CITY OF ALBUQUERQUE

**Re: Andaluia Villas, Tract 4 and 6 North Andaluia
Grading and Drainage Plan
Engineer's Stamp Date 6/04/2012 (E12/D015C)**

Based upon the information provided in your submittal received 8/07/2012, the above referenced submittal can not be reviewed for Building Permit Approval until the following comments have been addressed:

EXHIBIT A, Page 4 of 6

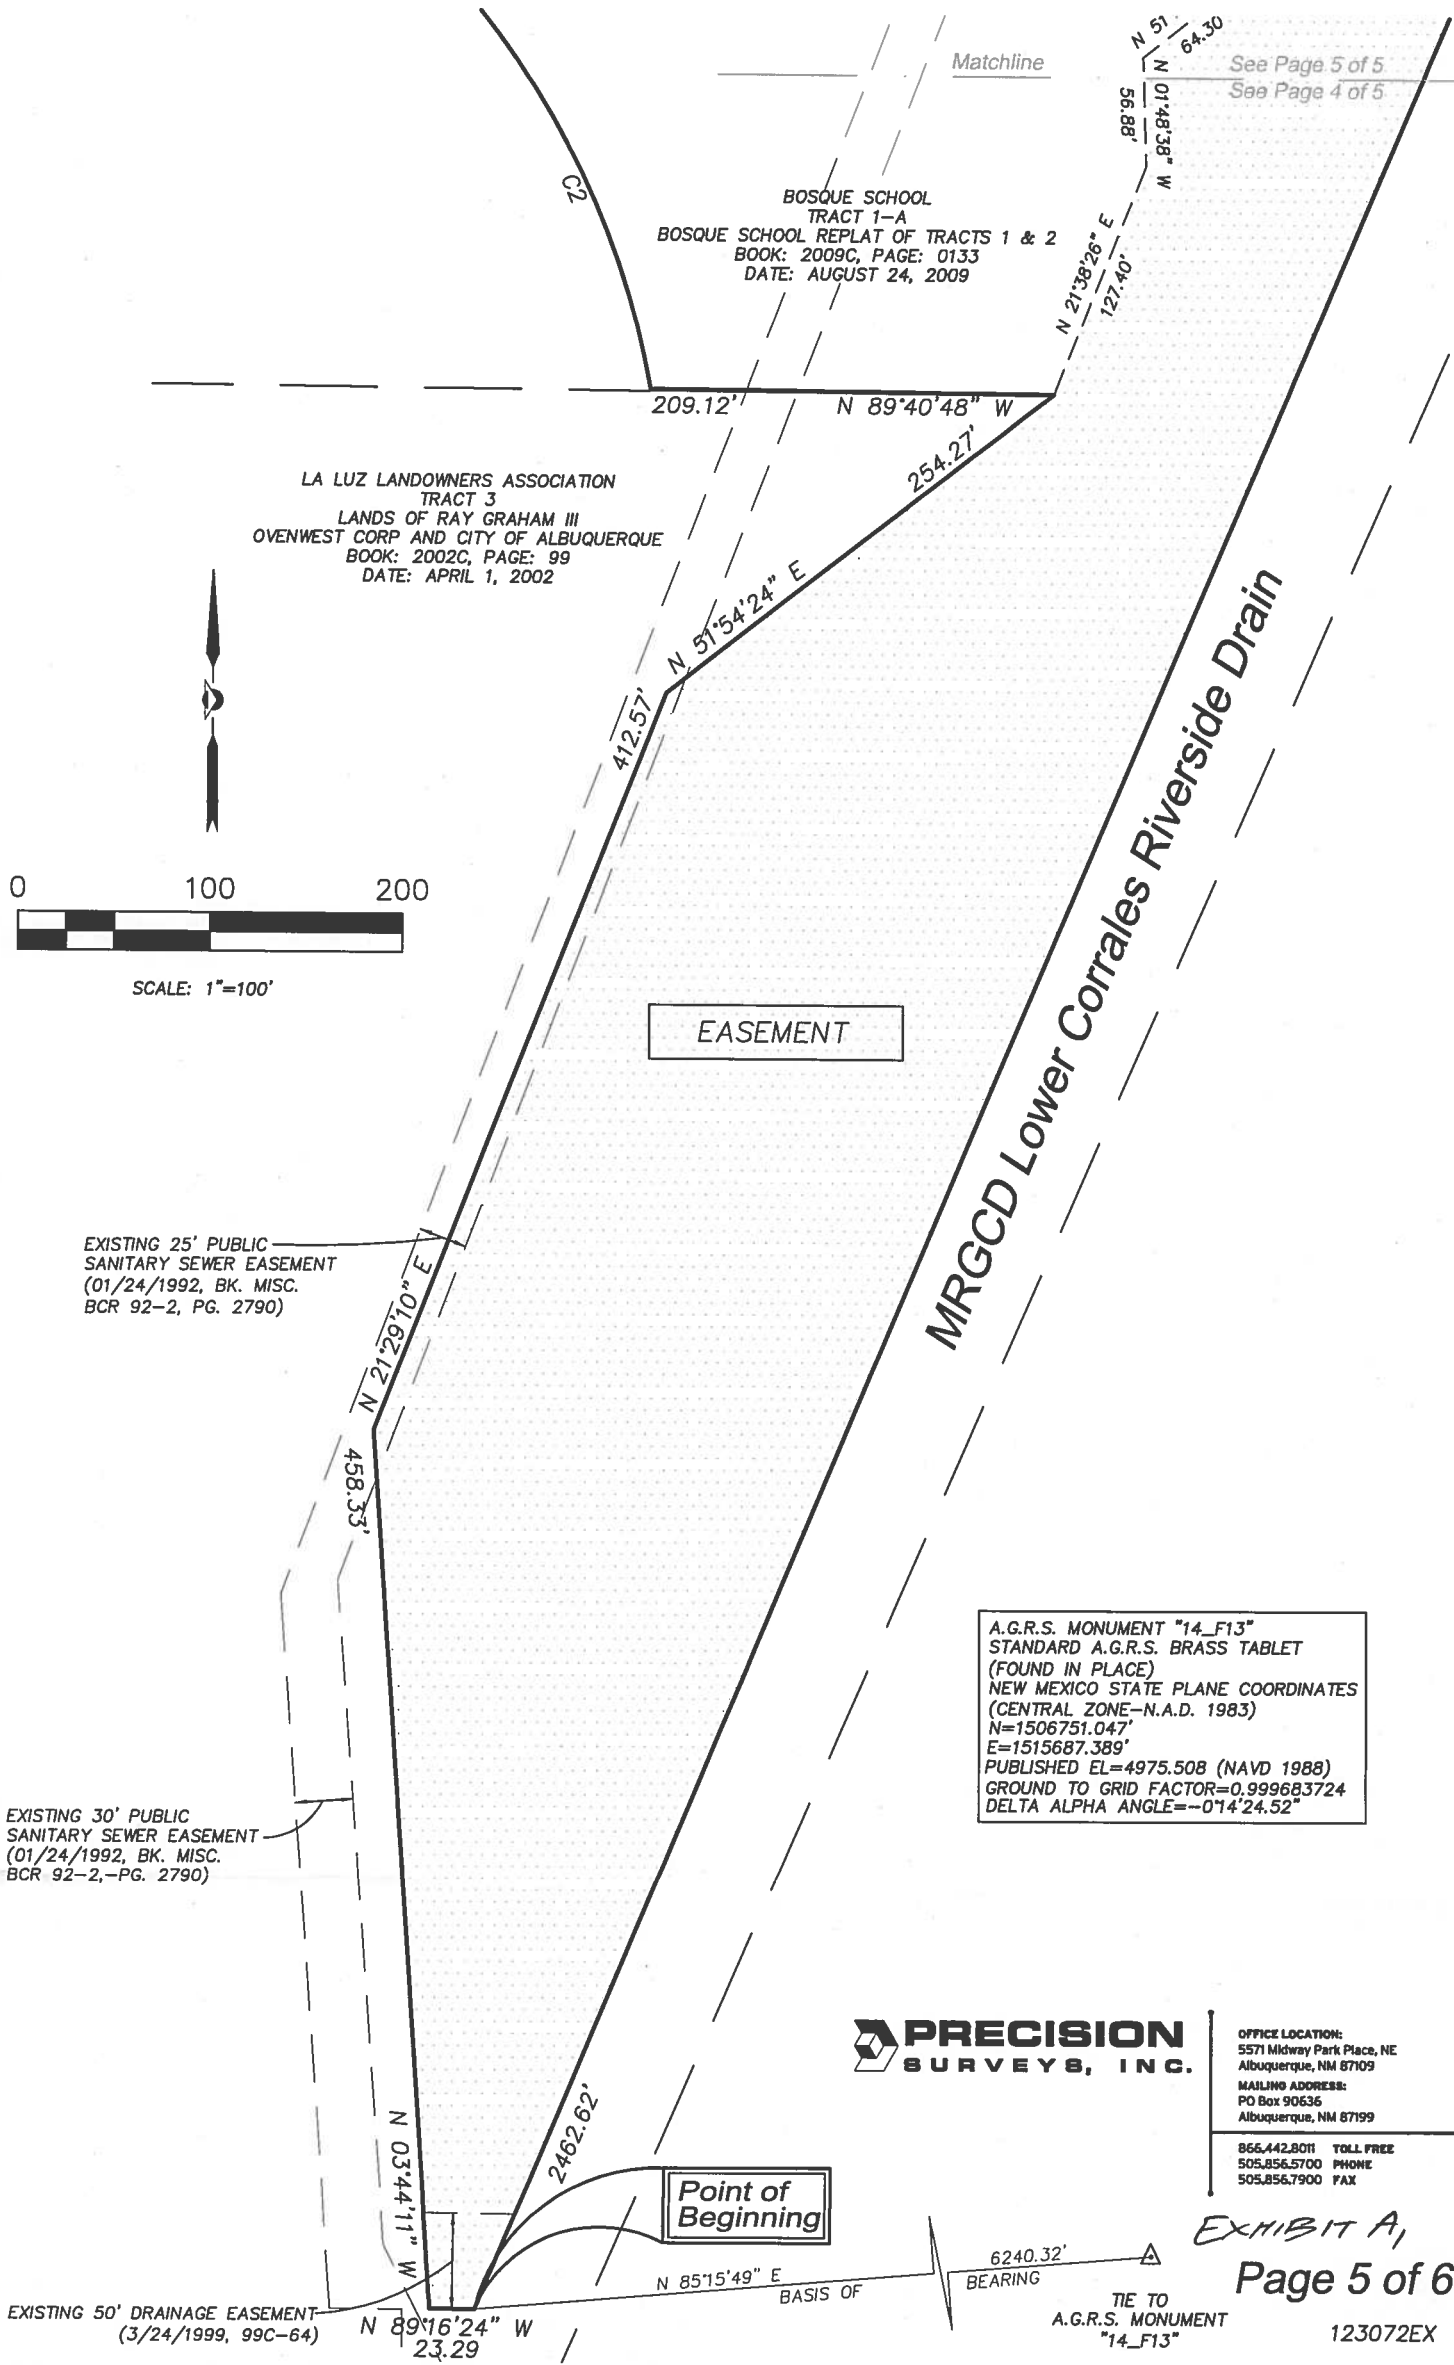
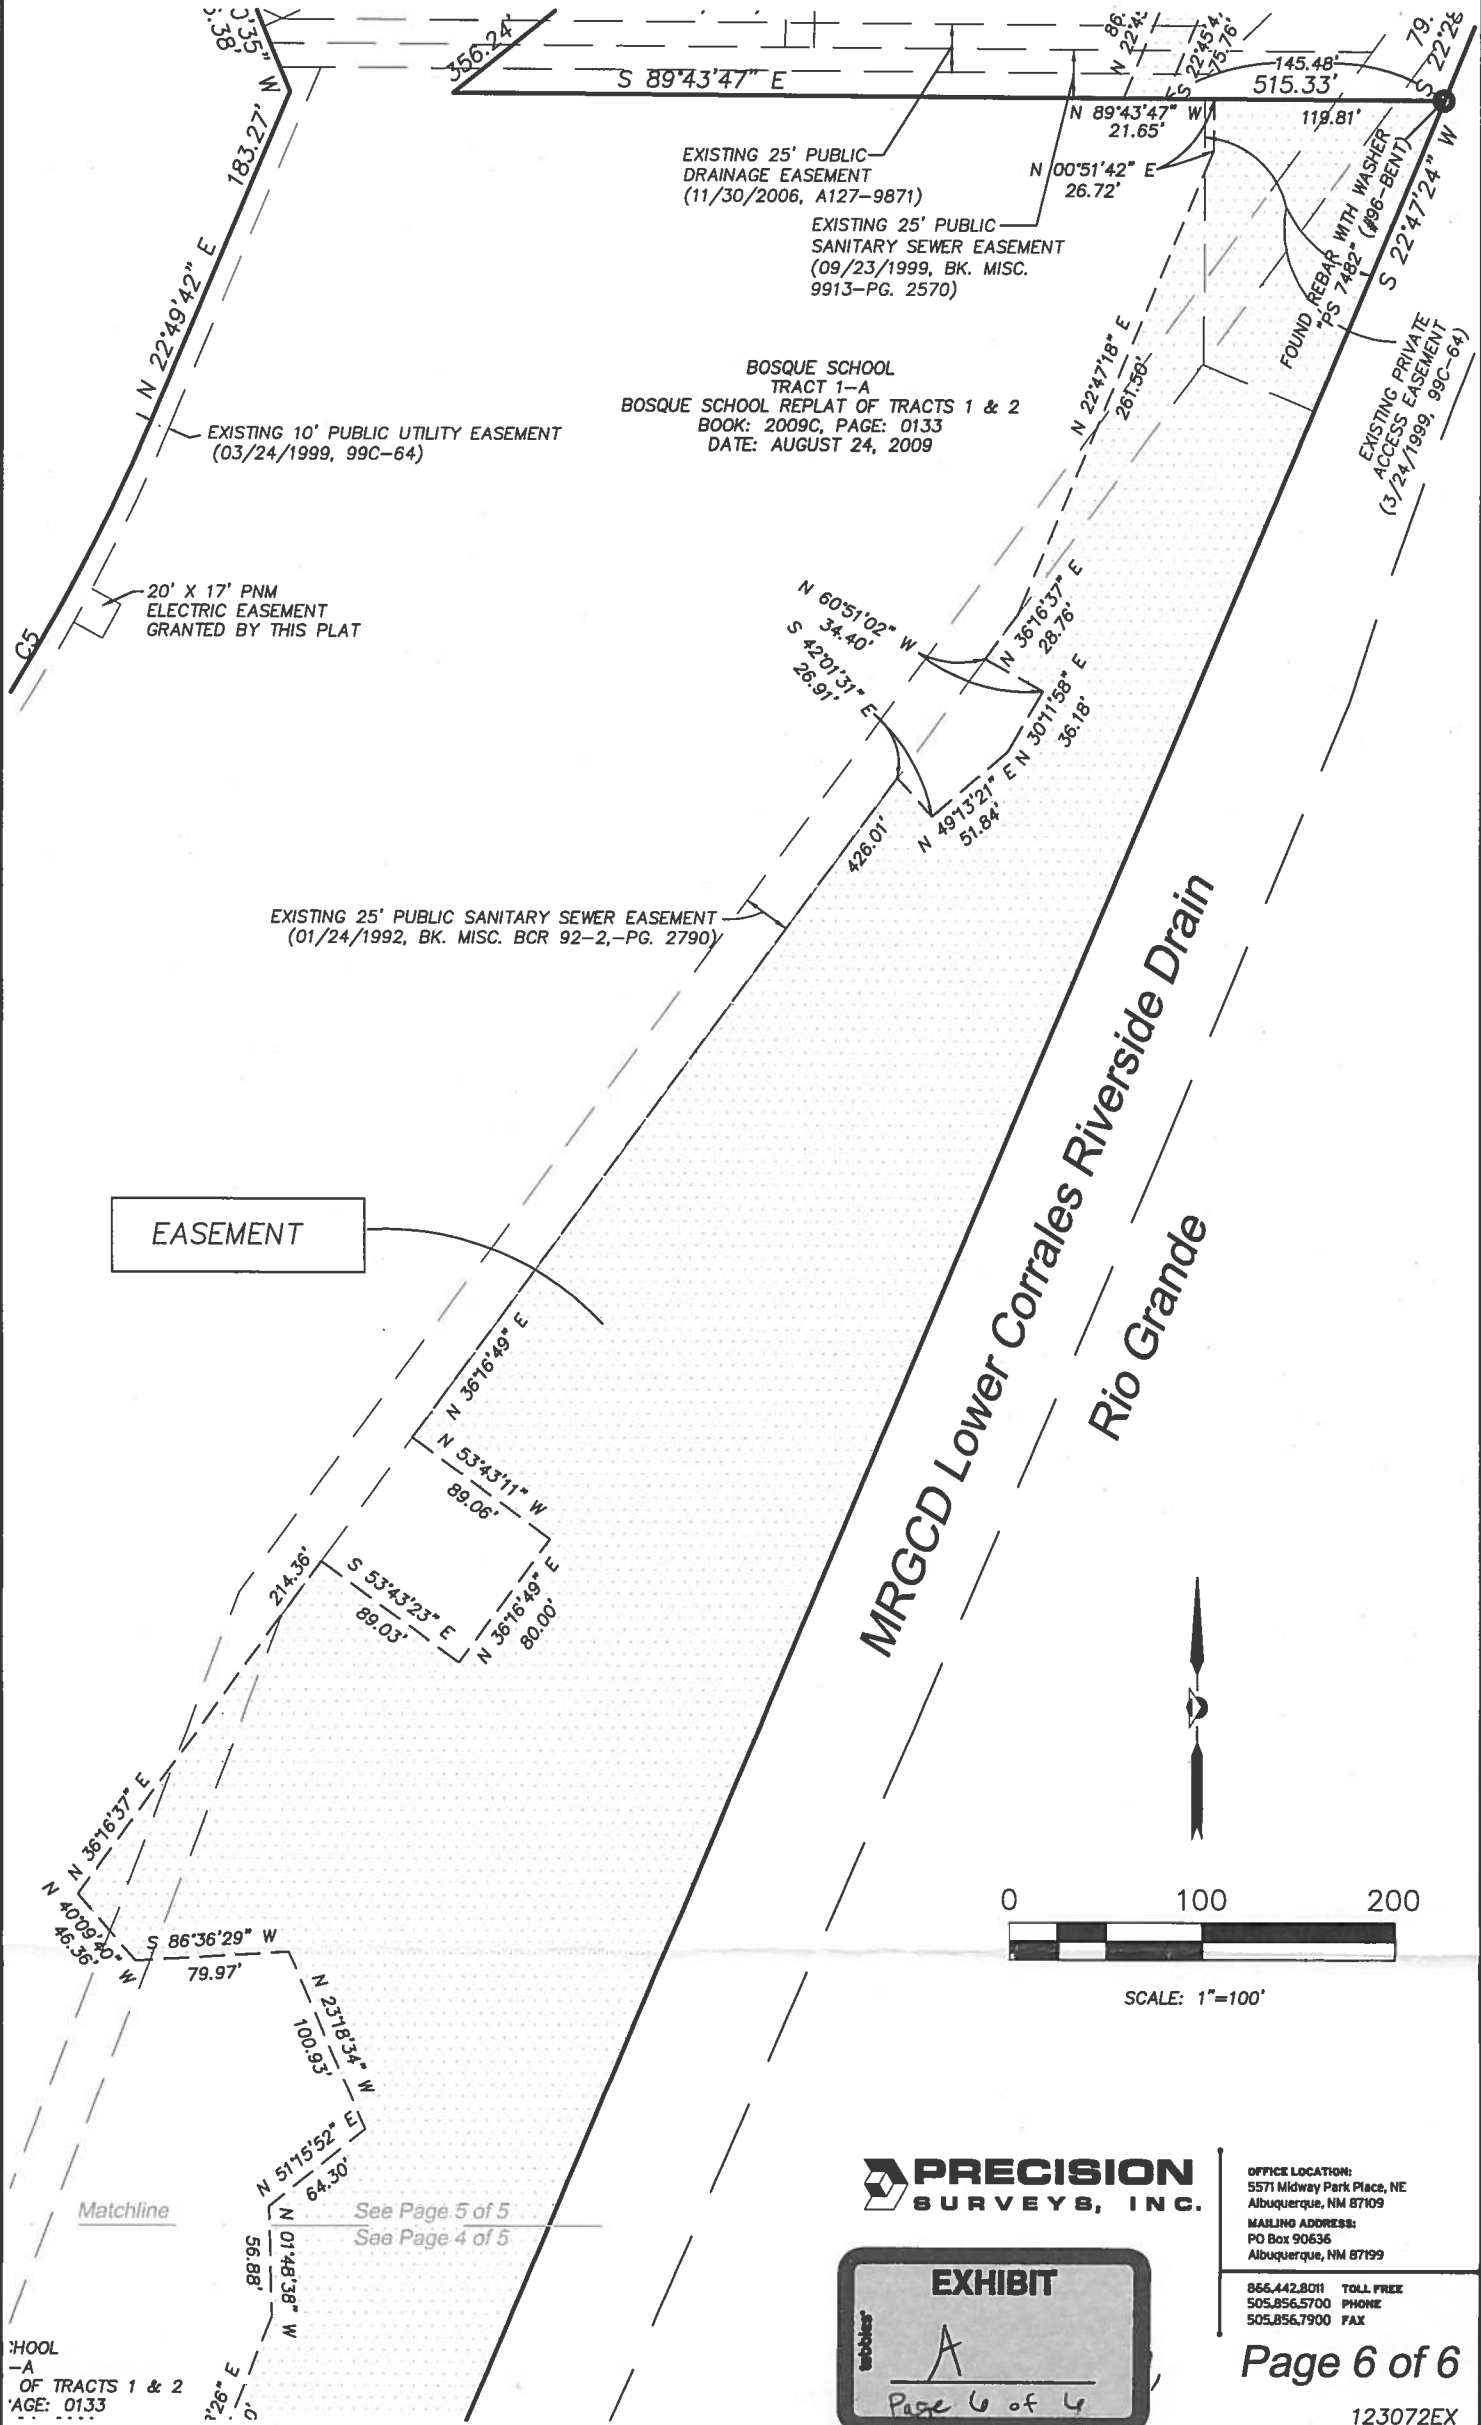
- The existing retention pond (Pond B) located on the east of the school has to be reanalyzed to assure it has adequate ponding capacity as it was intended on the Master Drainage Plan. Retention Ponds may be required for Andaluia Villas.
- The overflow from existing pond north of the school site (Pond A) to Pond B may have to be constructed. Does Pond A have to be regarded?
- Recorded drainage easement is required for Pond B.
